Royal Prince Alfred Hospital North West Precinct Redevelopment

PREFERRED PROJECT REPORT

Architectural Design Statement

Document Reference: 3599-0603-011

**DEPARTMENT OF PLANNING SUBMISSION**  
**LEVEL 1 PLAN - AMBULATORY CARE - SATELLITE**  
**RENAL DIALYSIS**  
 ROYAL PRINCE ALFRED HOSPITAL  
 North West Precinct Project, Camperdown

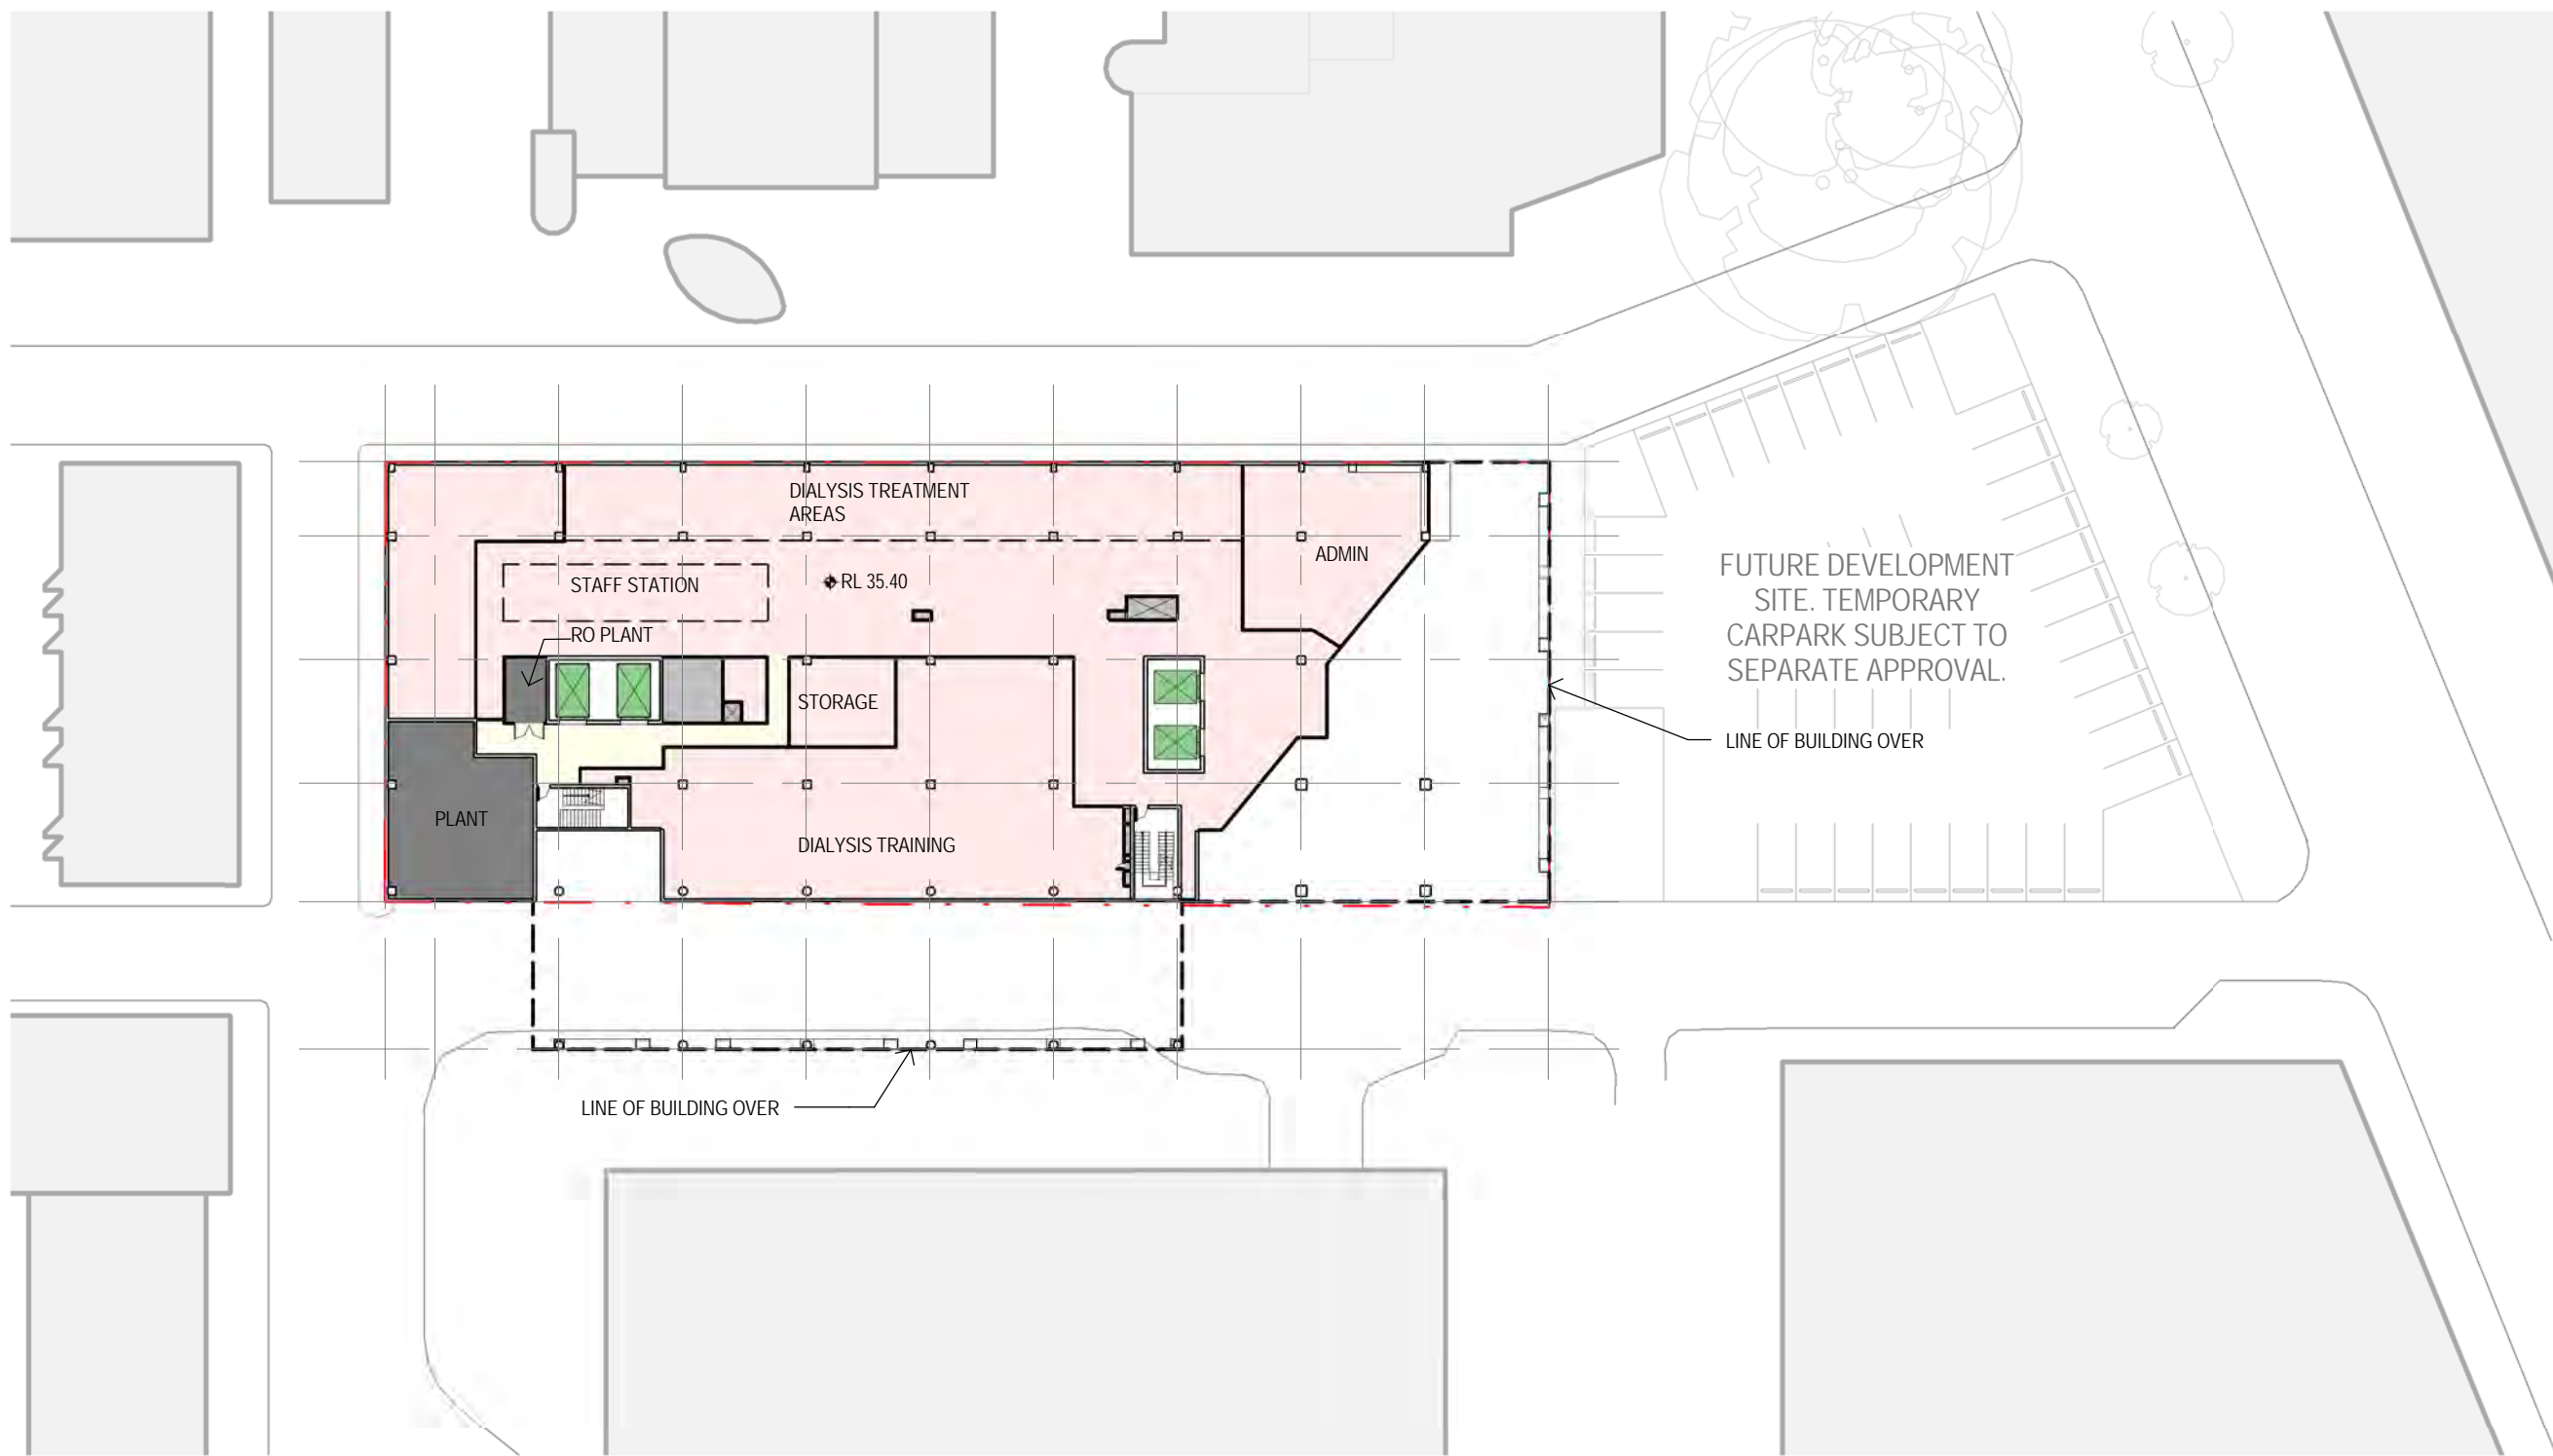
- The east glazing extent is amended to align with the ground level accommodation and the incorporation of the dedicated Lucas Street entry;
- The extent of specific department accommodation within the Unit has varied in developing the design; and
- The location and extents of plant and storage has varied in developing the design.

**DEPARTMENT OF PLANNING SUBMISSION**  
**LEVEL 2 PLAN - AMBULATORY CARE SERVICES**  
 ROYAL PRINCE ALFRED HOSPITAL  
 North West Precinct Project, Camperdown

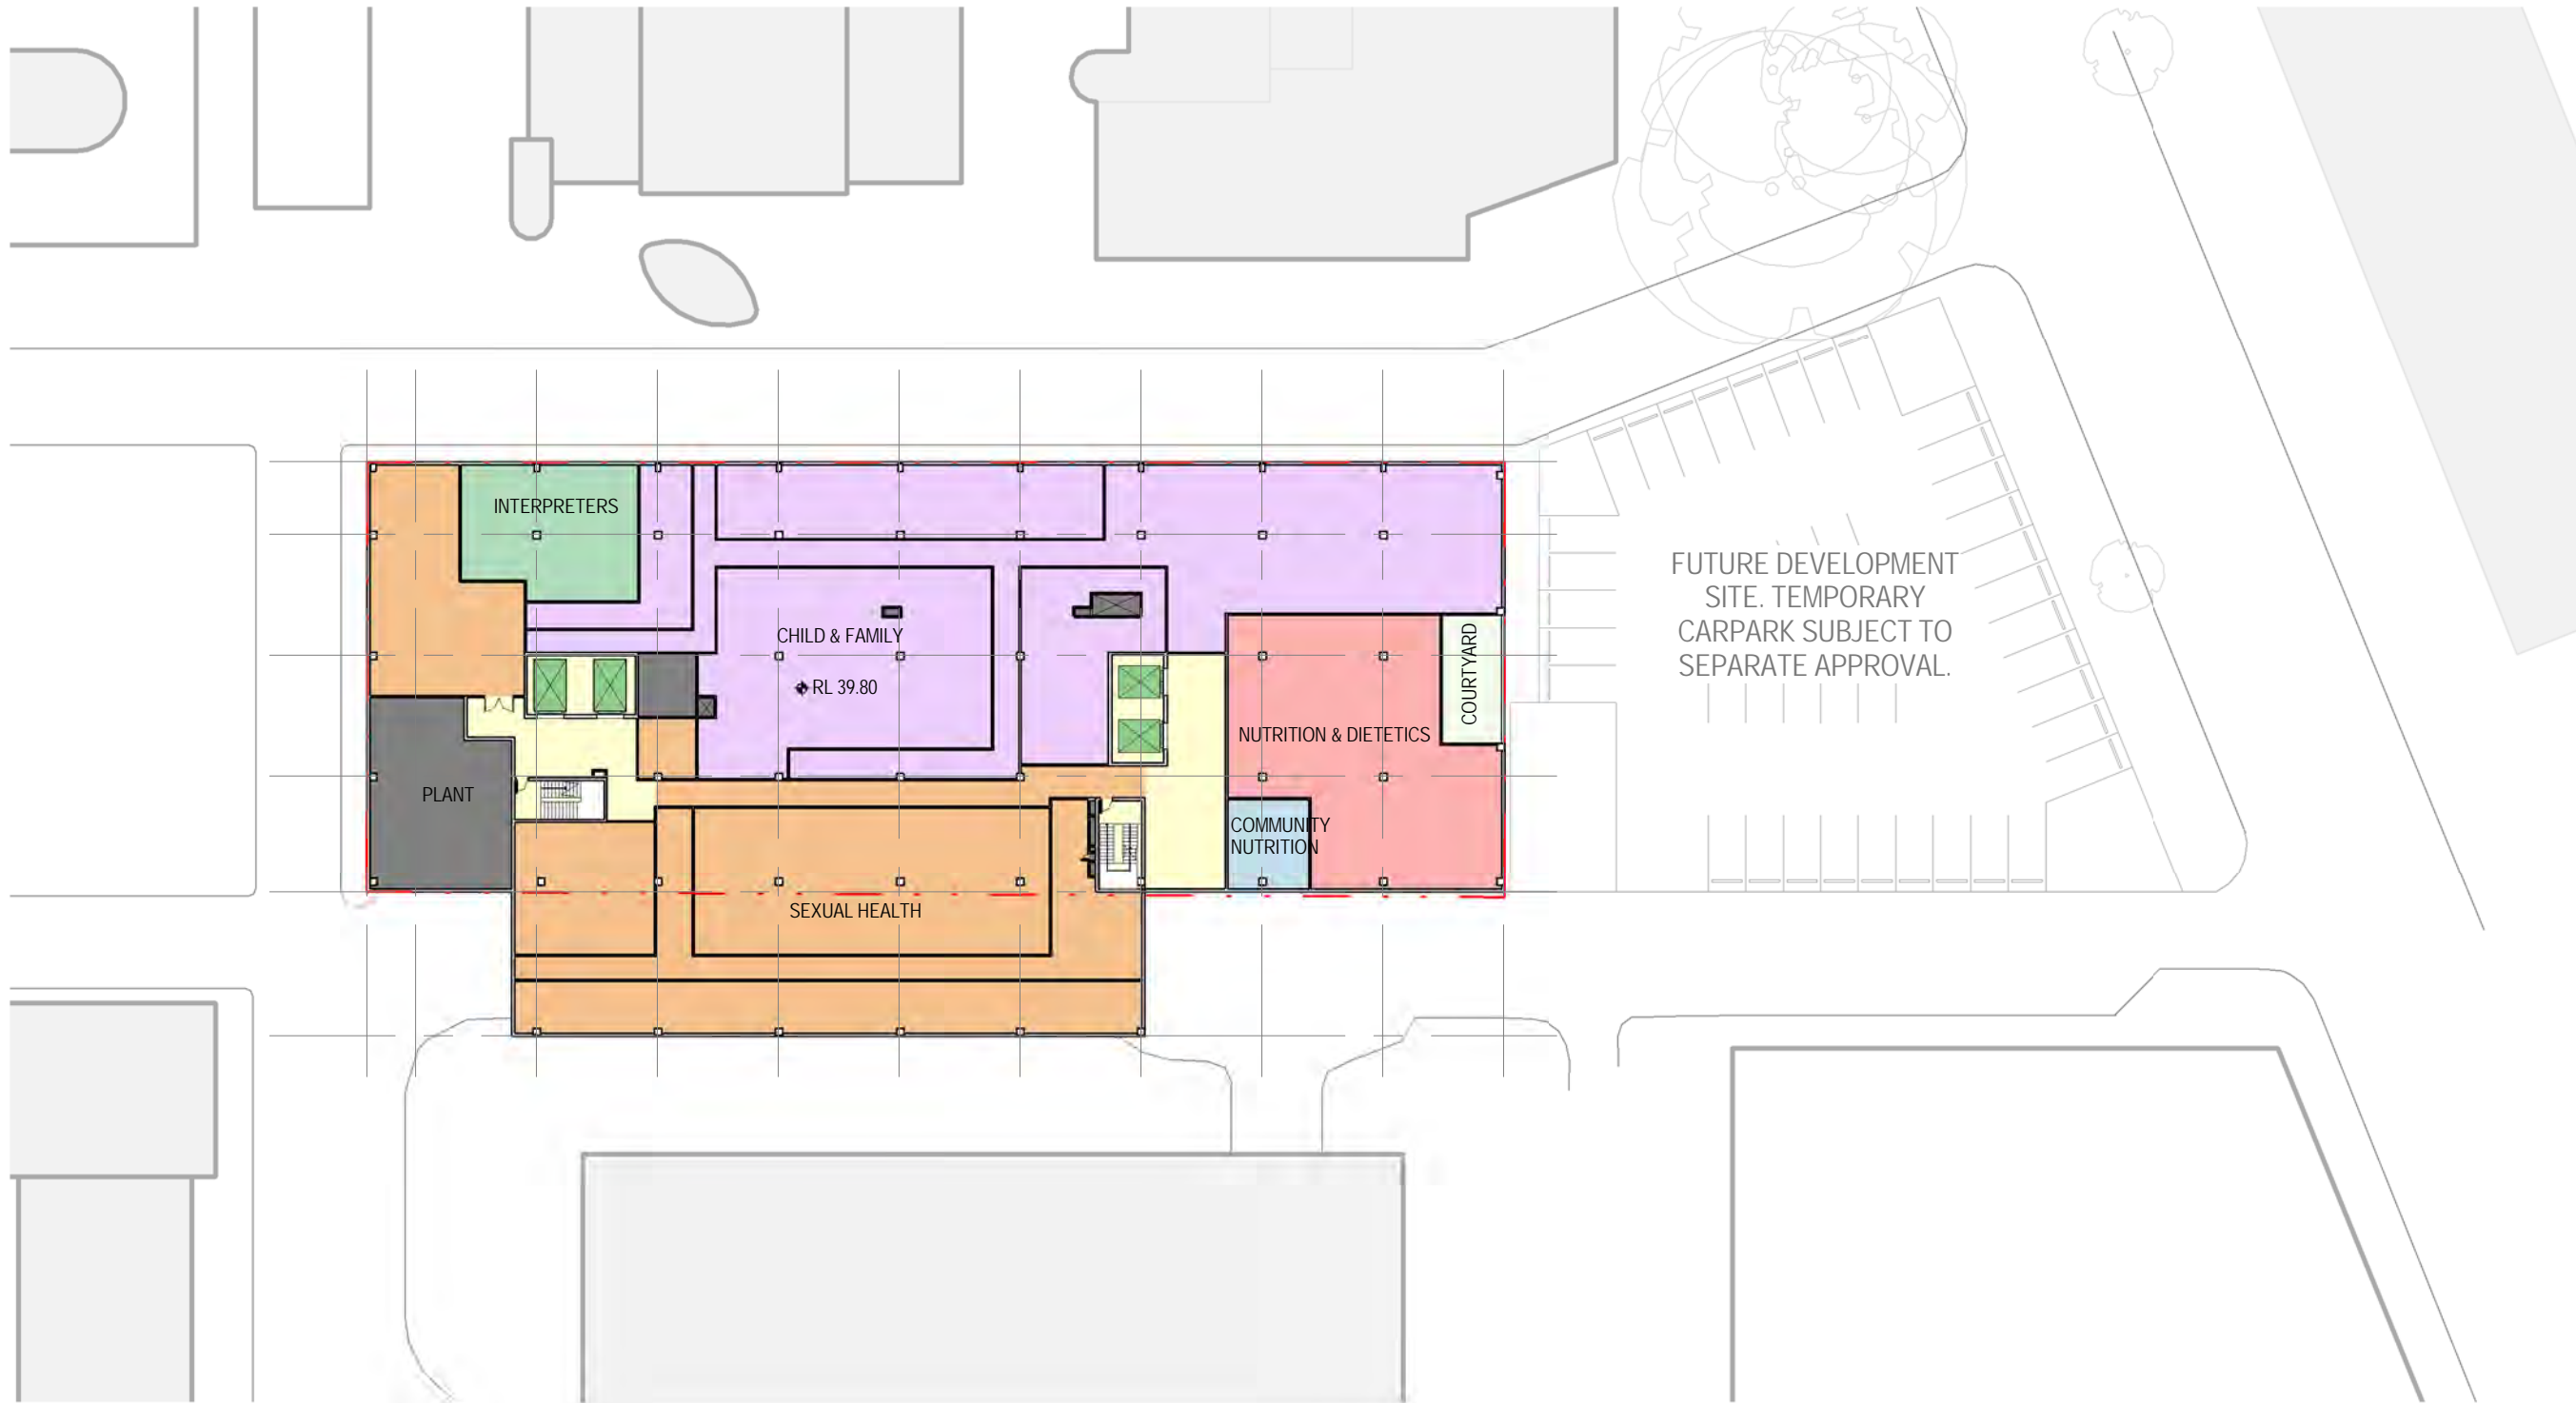
- The north perimeter incorporates indents to assist breaking down the visual bulk of the building and provide relief in the floor plate configuration; and
- The extent of each Unit within this floor level has varied to achieve the functional accommodation requirements.

**LEVEL 6 PLANT**

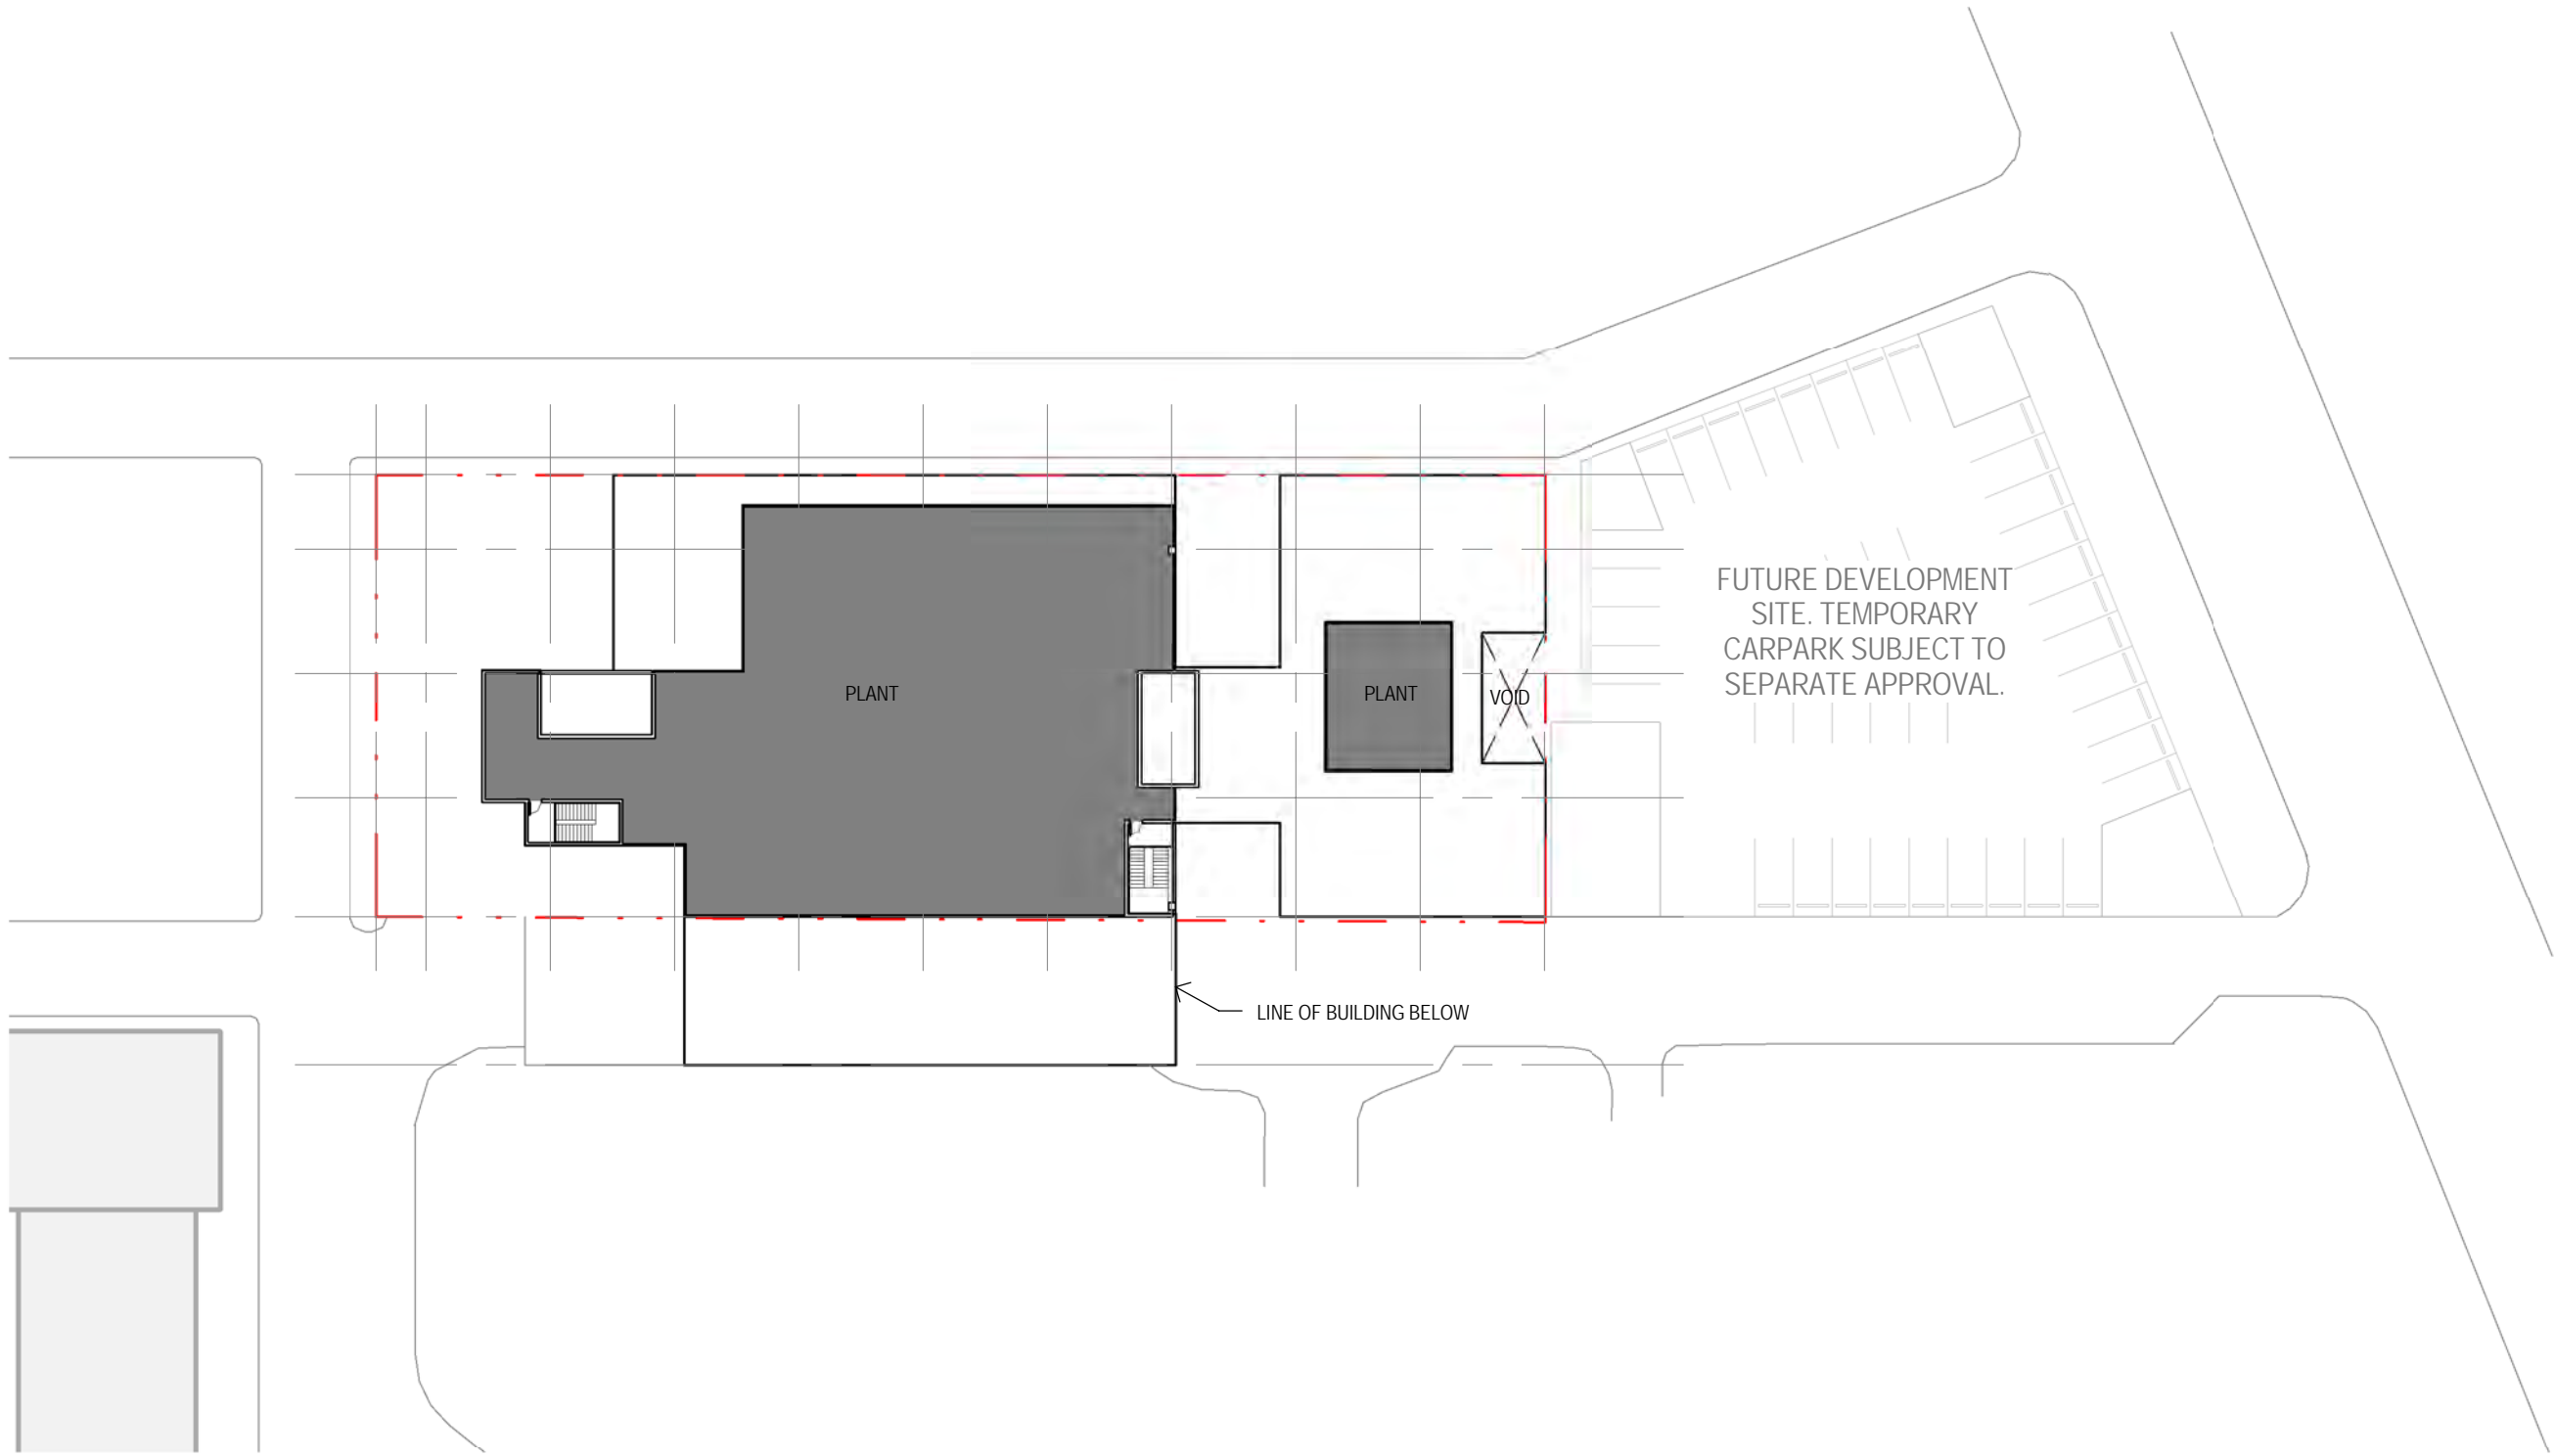
- The extent and configuration of the plant and equipment has been further developed; and
- Pitched roof design to both Level 5 roof and Plant roof.
